Arun District Council
Arun Civic Centre
Maltravers Road
Littlehampton
West Sussex BN17 5LF
Planning General Enquiries
Tel: (01903) 737756 Fax: (01903) 730442
Dx: 57406 Littlehampton
Minicom: 01903 732765
e-mail: planning@arun.gov.uk
website: www.arun.gov.uk/planning

Your Ref: BR/37/18/DOC
Please ask for:
Mr R Temple
21 March 2018

Town & Country Planning Act 1990 (as amended)
Town and Country Planning (Development Management Procedure) (England) Order 2015
Application for approval of details reserved by condition imposed under planning permission
BR/292/16/PL (Appeal ref. APP/C3810/W/17/3169745) relating to condition No. 2 2) Details of the
head, sill, mullions, jambs & glazing of the replacement windows on the North East elevation
1 Regis House Richmond Road, Bognor Regis,

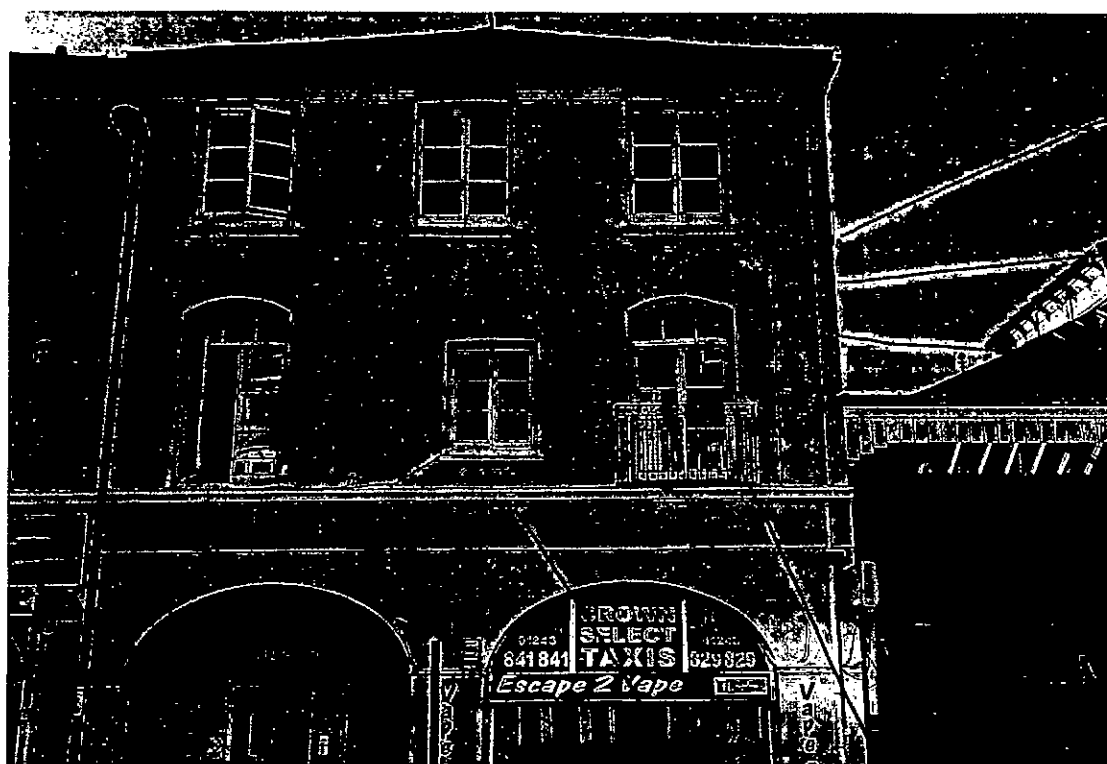
The submitted plans of joinery details are insufficient to make a decision. They are unscaled, and do not describe elements as set out in the Appeal Decision. It is also noted that no block plan has been submitted to locate the windows being replaced.
